Your ref: SSD-77458970
Our ref: DOC26/55740

Subject: Environmental Impact Statement – Mixed-use residential and commercial development (SSD-77458970)

CPHR advice on EIS - Mixed-use residential and commercial development, 135 Badgerys Creek Road, Bradfield

PROPOSED NEW STREET LONG SECTION

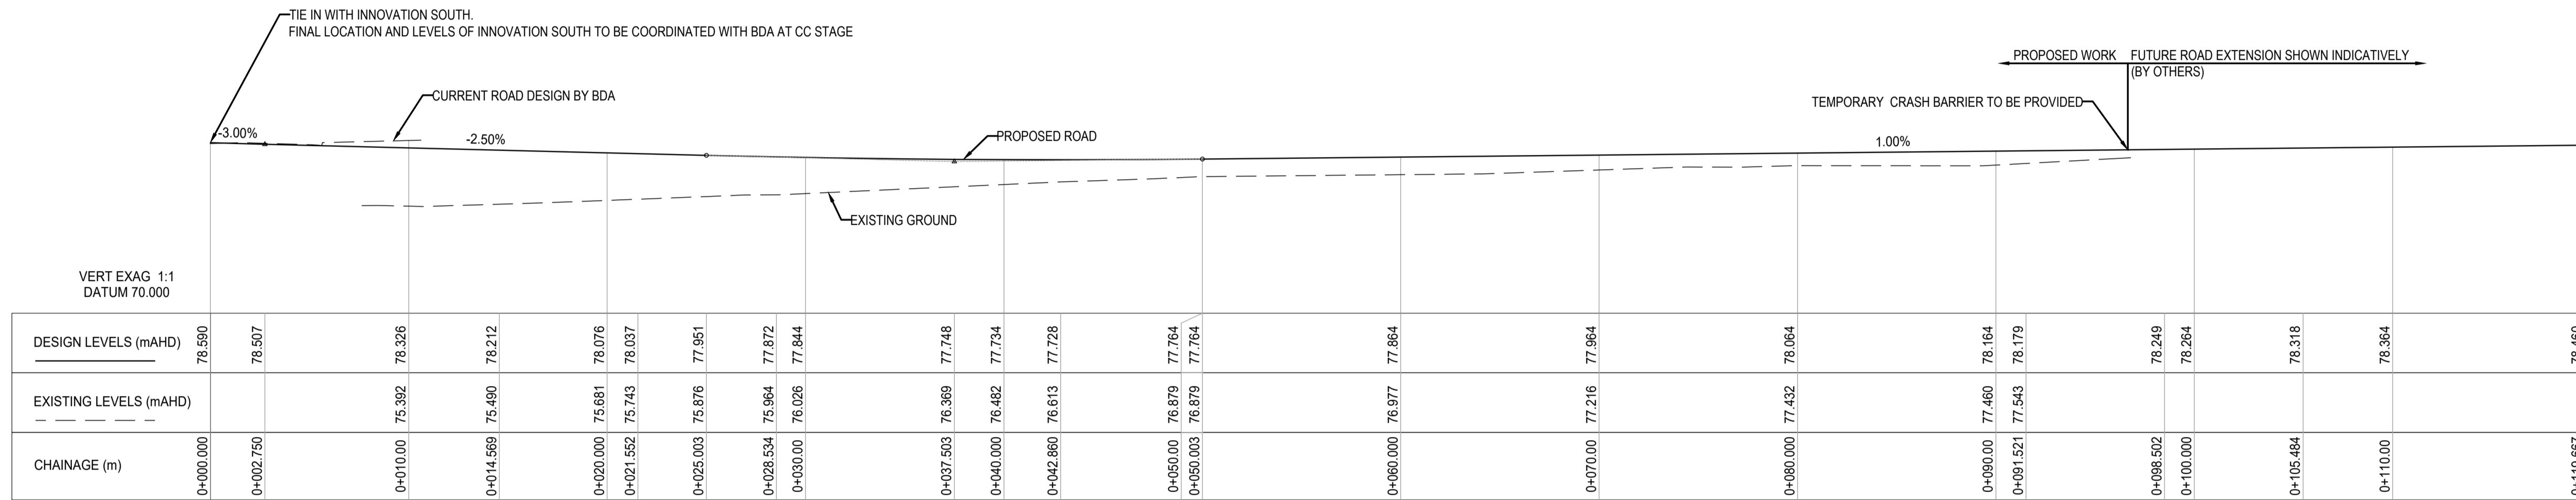
4	<i>Emergency Management</i>	The site appears to be accessible in all flood events including the PMF through the proposed Innovation Road which runs along the southern boundary of the site to Badgerys Creek Road which is impacted by H1 hazard flow in the PMF. The 'Proposed New Street' that bisects the site will be cut in the PMF and should be avoided in larger flood events. Recommended action: Update the business Flood Emergency Response Strategy to specify that the 'Proposed New Street' is to be closed during rare flood events.
	<i>Extent and timing</i>	Pre-determination

# Landscape Master Plan

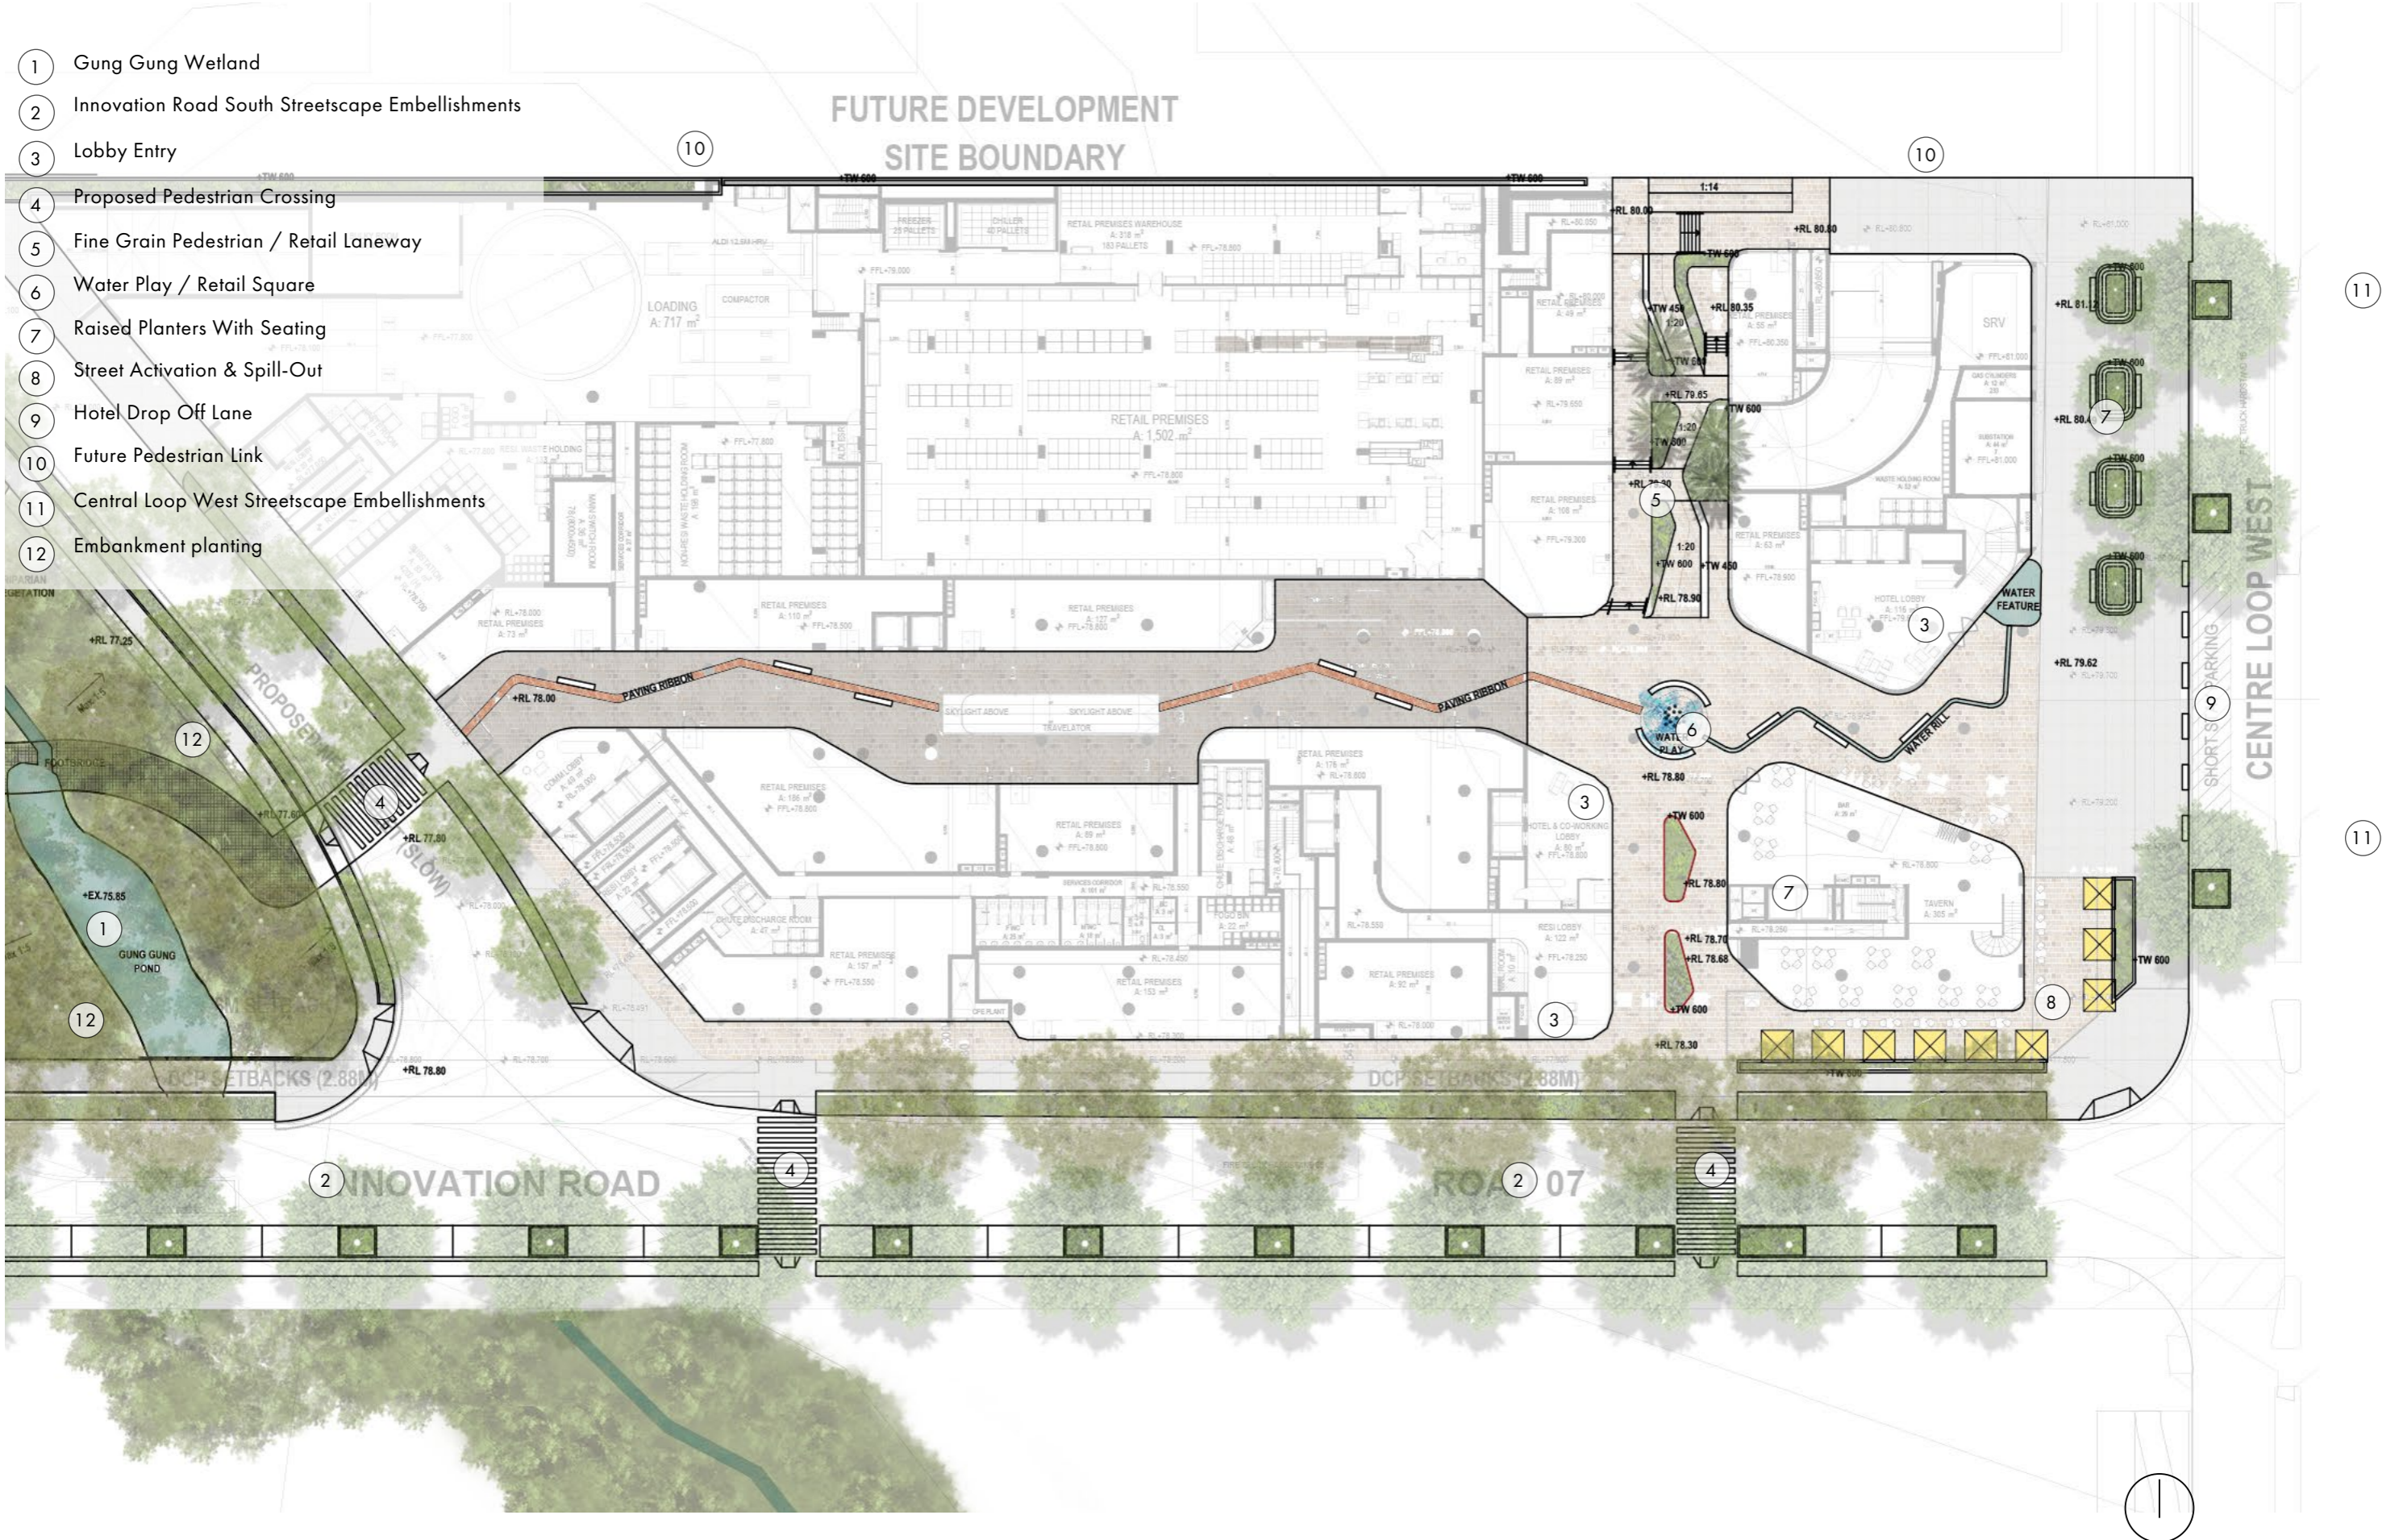
1	<i>Recommendations from the Bushfire Assessment and Landscape Design Report & Plan do not match the management of vegetation cover</i>	The Bushfire Assessment indicates that the site will be managed to inner protection area (IPA) standards in accordance with the Planning for Bush Fire Protection 2019 (NSW Rural Fire Service, November 2019)(PBP 2019) which states that tree canopy cover should be less than 15%. The Landscape SSDA Design Report states the proposed target canopy coverage is 21%. Recommended action: Confirm the Landscape SSDA Design Report are compliant with PBP 2019 or provide further justification in the Bushfire Assessment that the increase canopy coverage is appropriate.
	<i>Extent and timing</i>	Pre-determination
